**Our ref:** WA/2013/116404/03-L01  
**Your ref:** 13/00304/DISC  
**Date:** 25 April 2014

**AMENDED DRAINAGE INFO. DISCHARGE OF CONDITION 2 OF 13/00822/REM OS PARCEL 6900 EAST OF OXFORD ROAD AND ADJOINING SOUTH OF CANAL LANE BODICOTE**

PROJECT:	LONGFORD PARK BODICOTE BANBURY		
DRAWING TITLE:	PHASE 1 ENGINEERING LAYOUT SHEET 1 OF 6		
CLIENT:	BARRATT HOMES, BOVIS HOMES TAYLOR WIMPEY		
DRAWING NUMBER:	20488_02_150		
REVISION:	E	SHEET SIZE:	A1
		DATE:	04.10.13
DRAWN BY:	MJK	CHECKED BY:	EM
		SCALE:	1:200

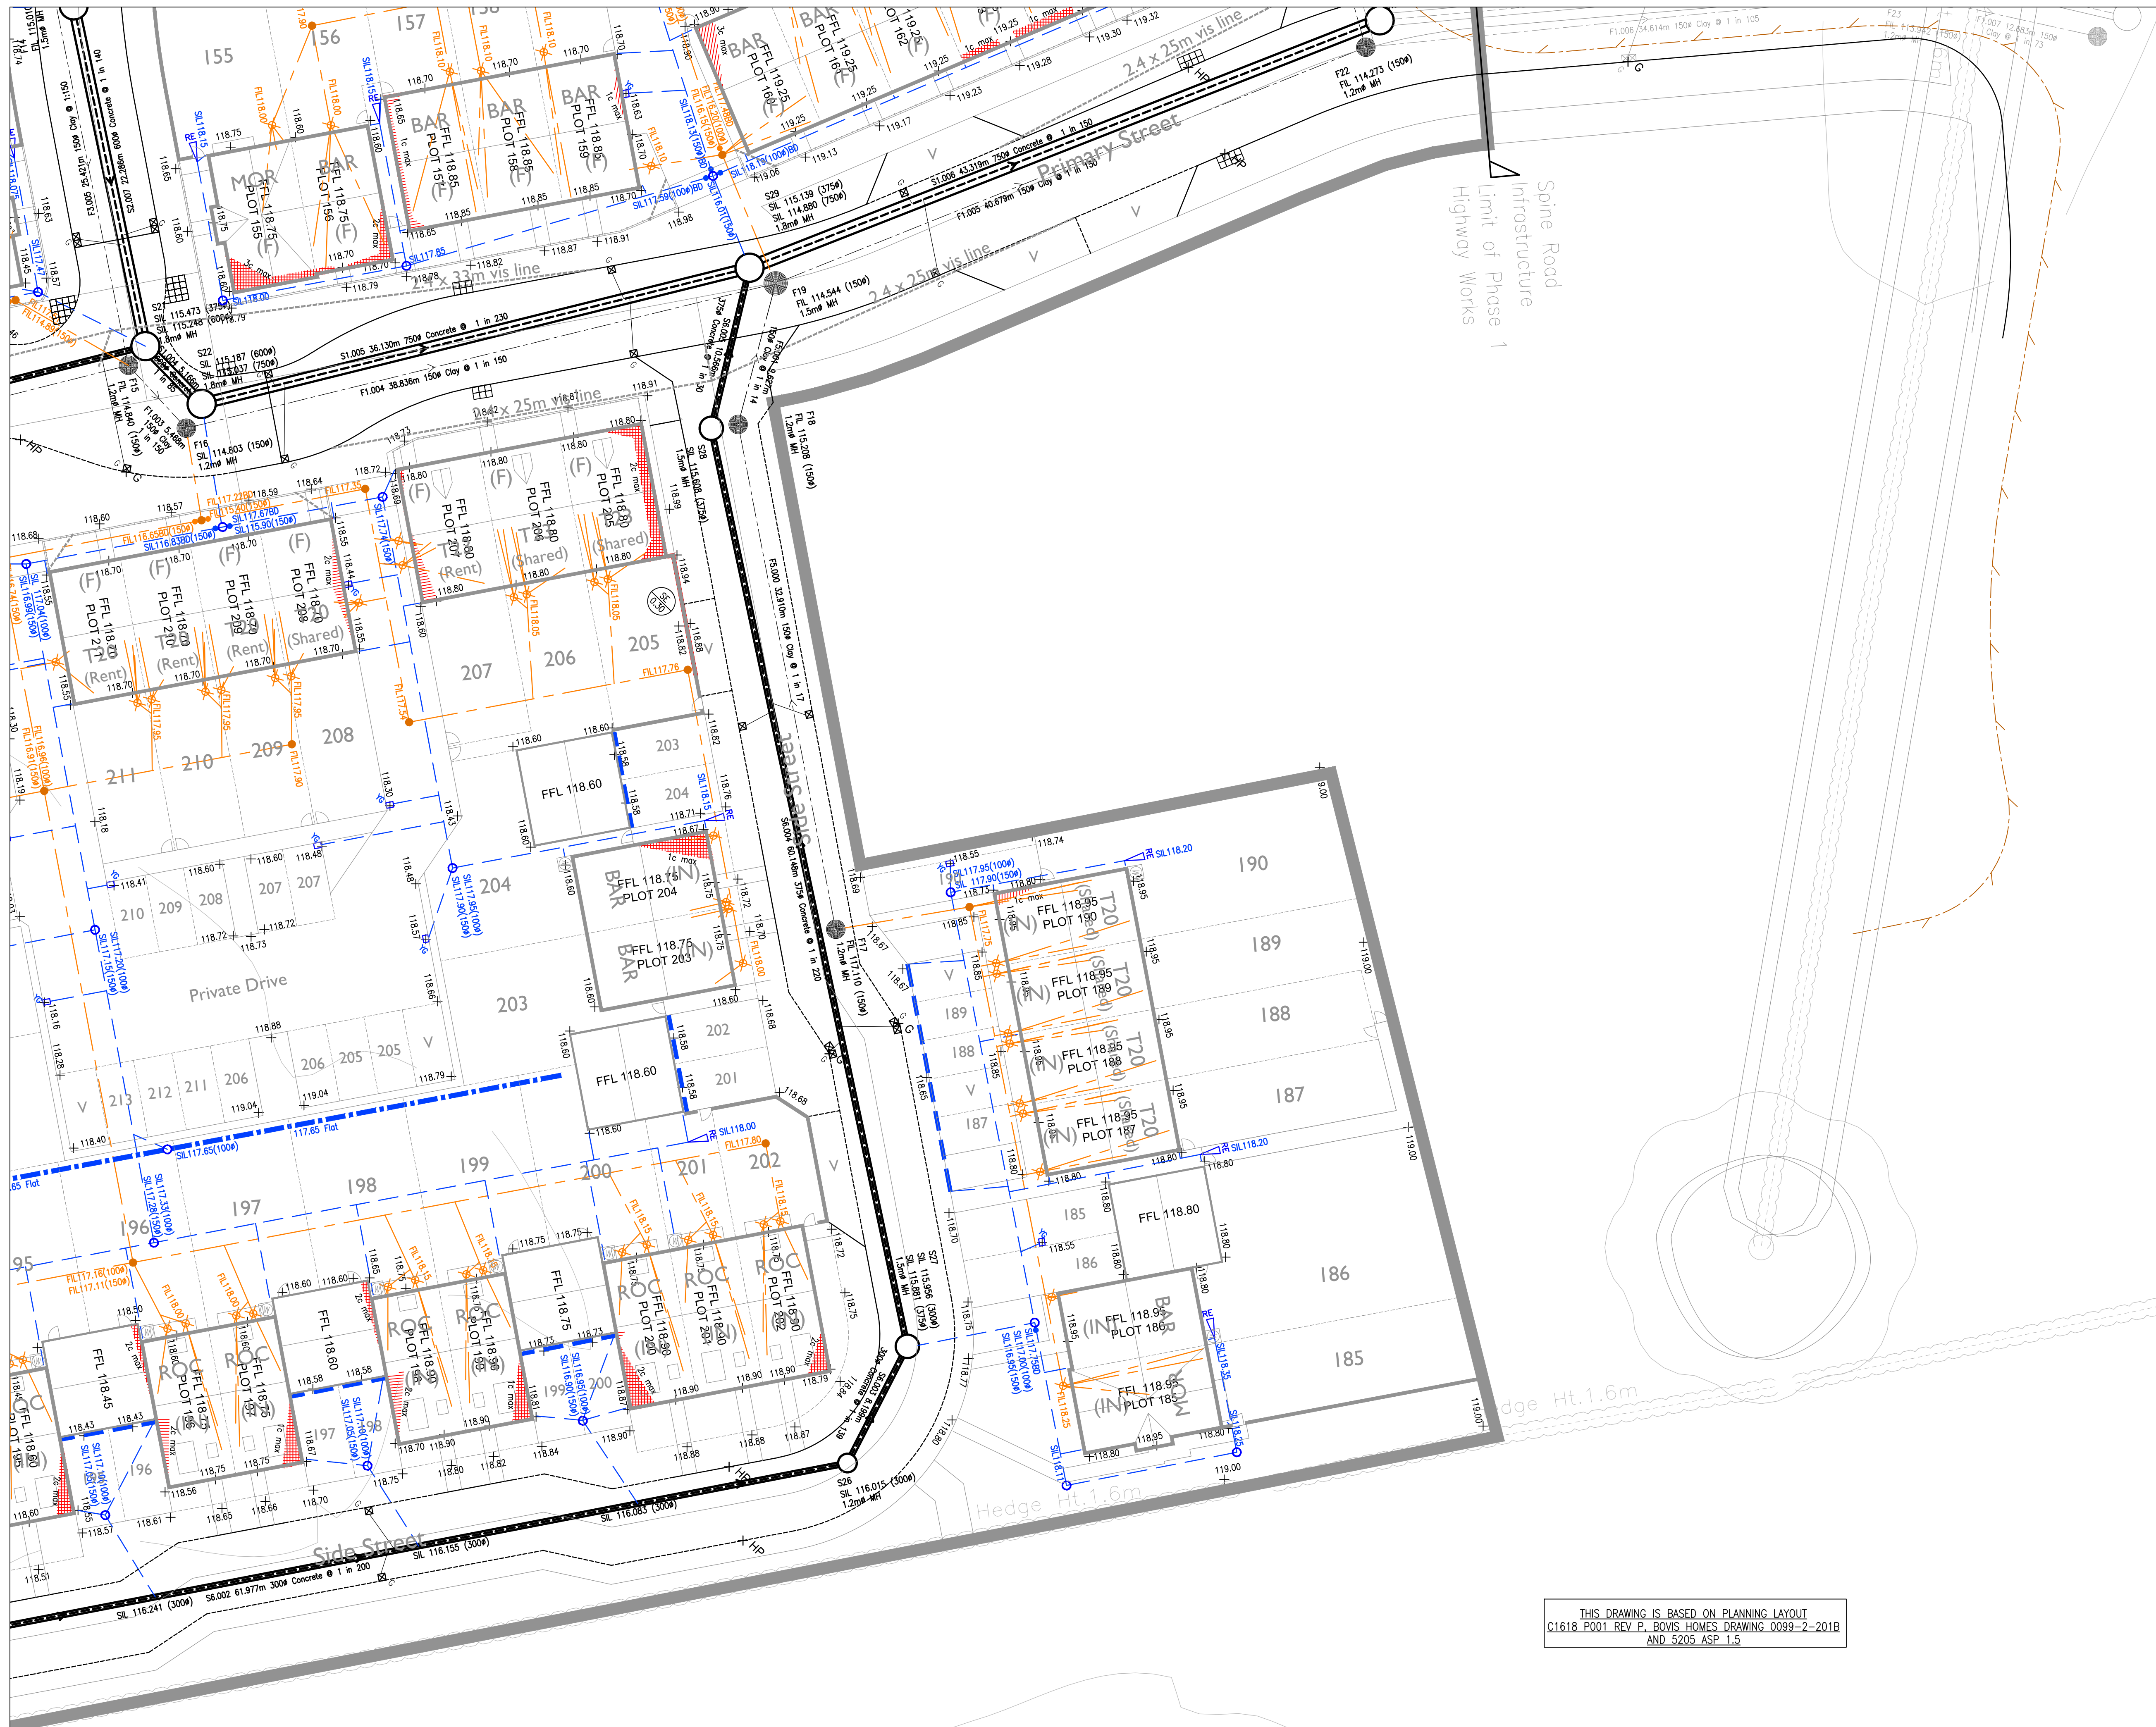
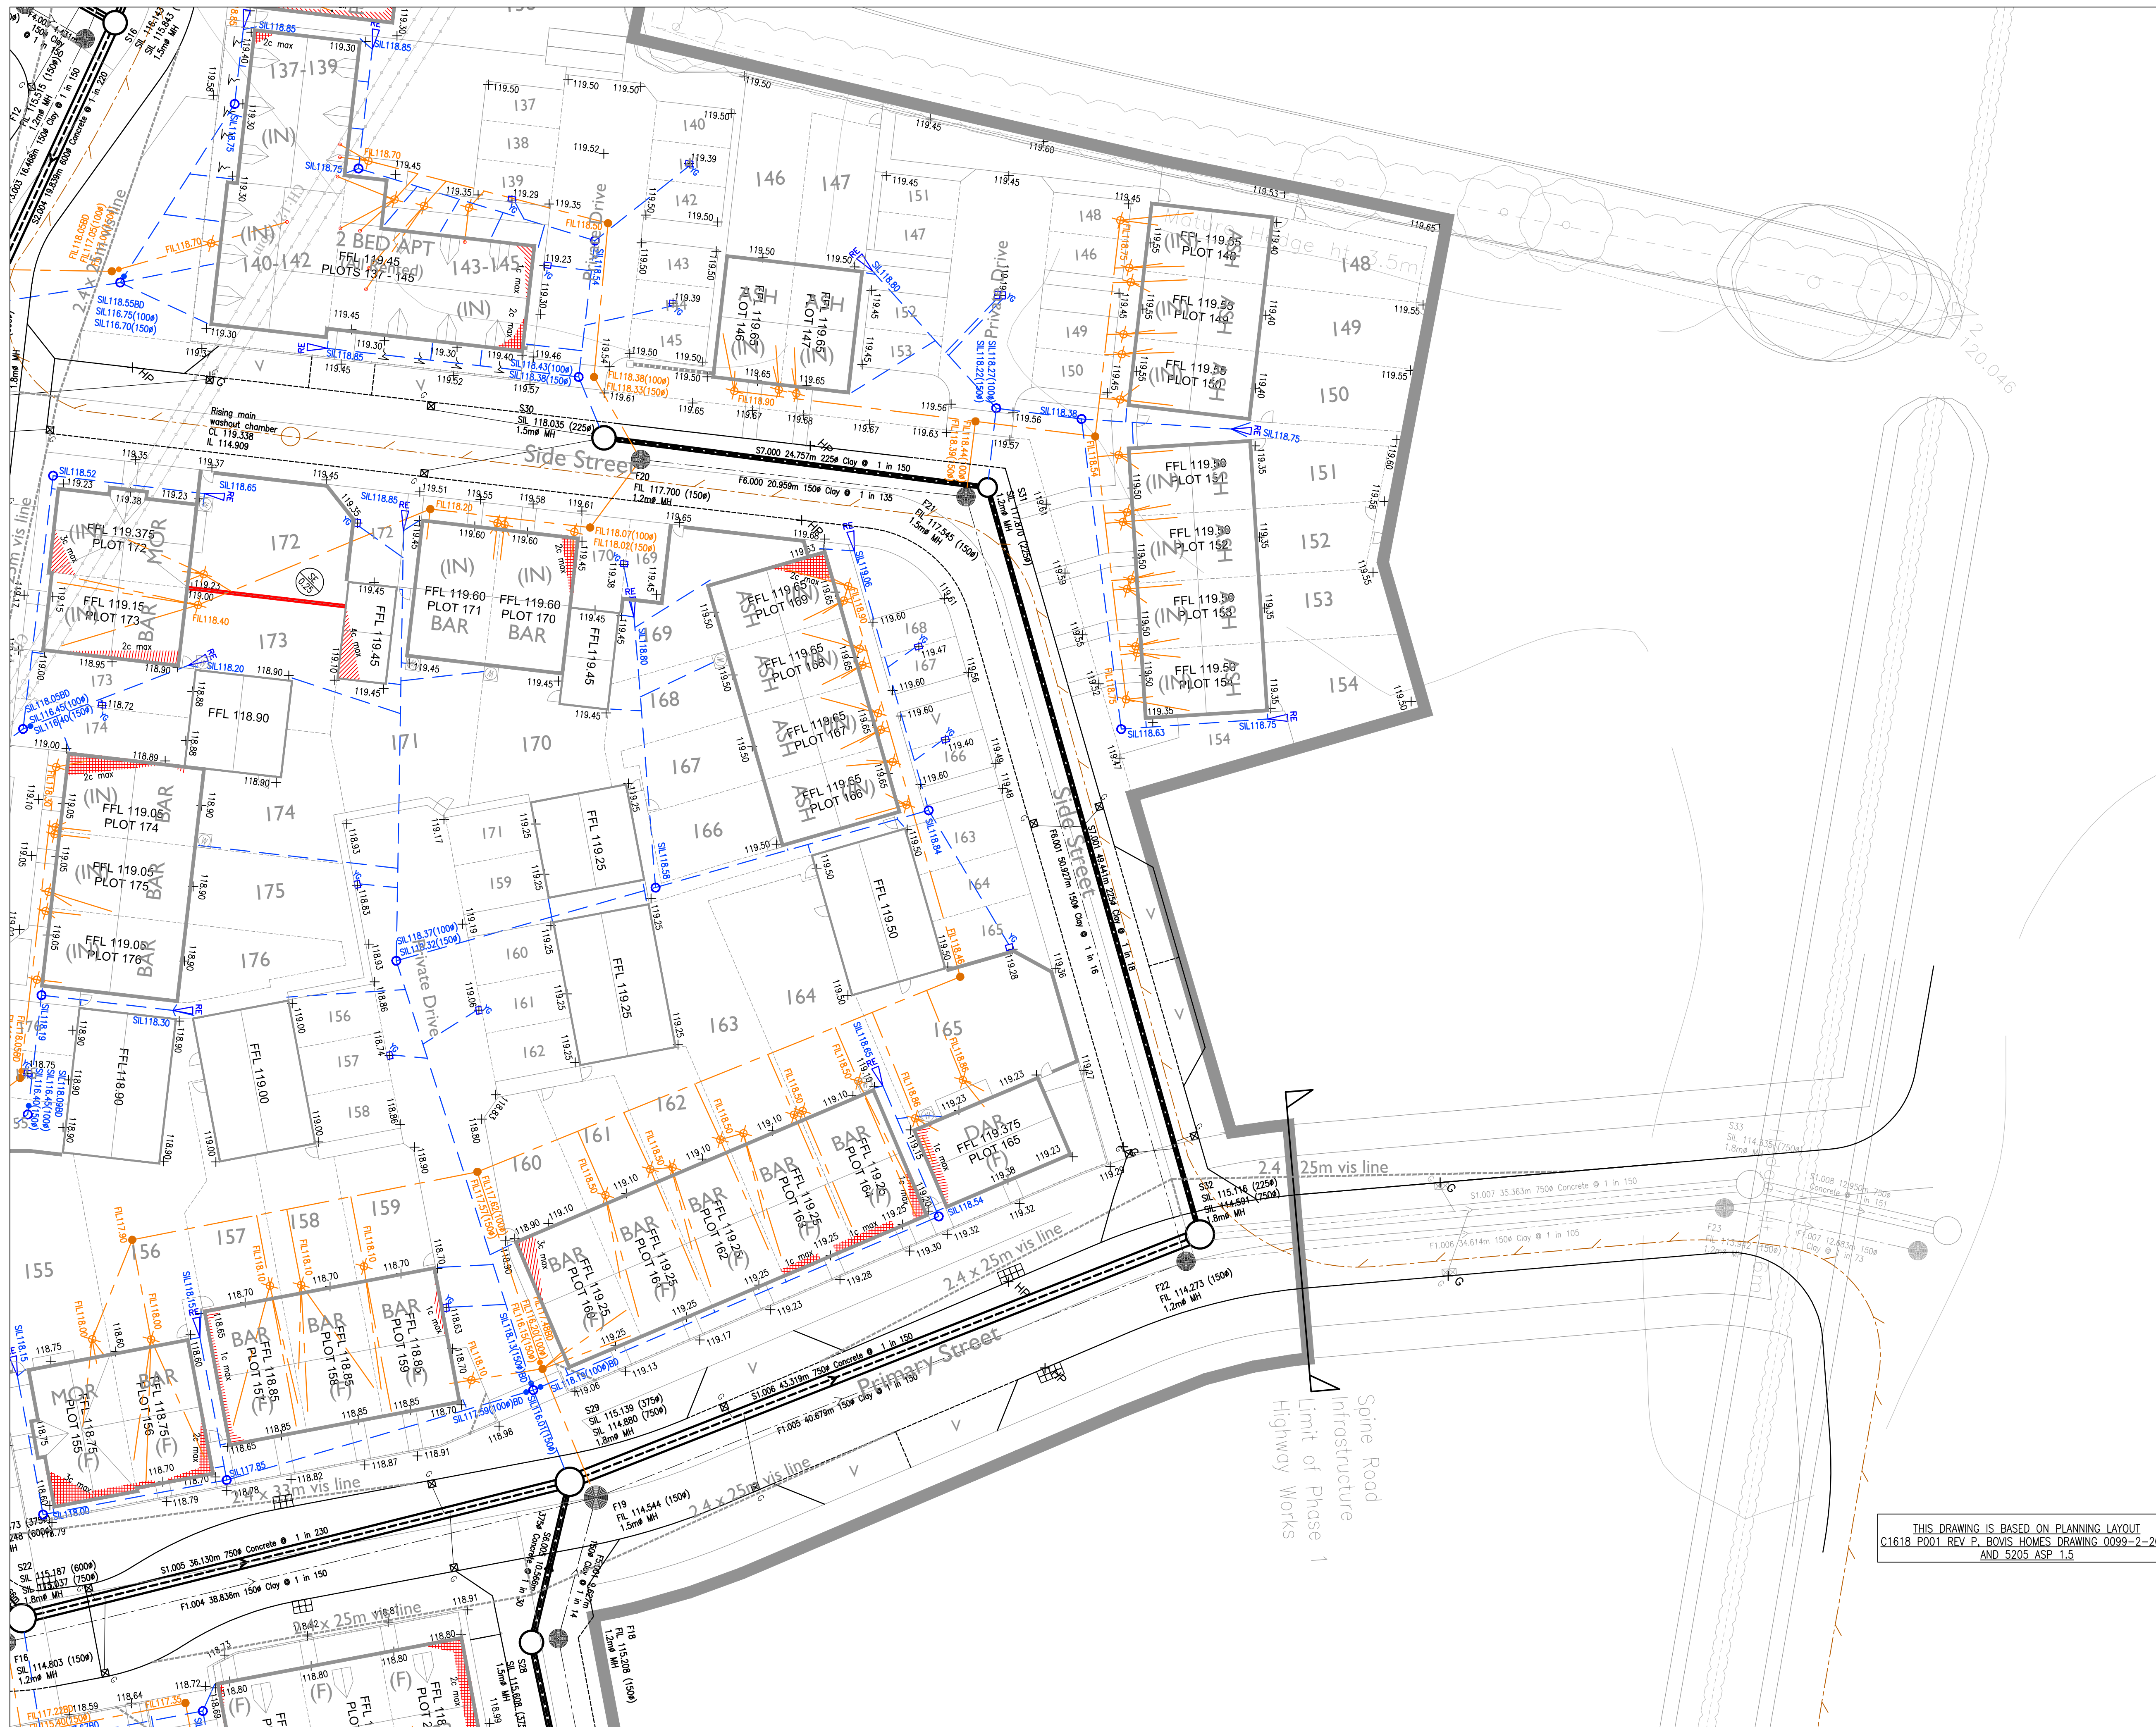
As a specific query on the current detailed submission we note that there are areas where flooding of the network occurs. Due to the significant flooded depths it is assumed that this occurs where the network outfalls to strategic drainage features. Please can the applicant confirm whether this is the case.
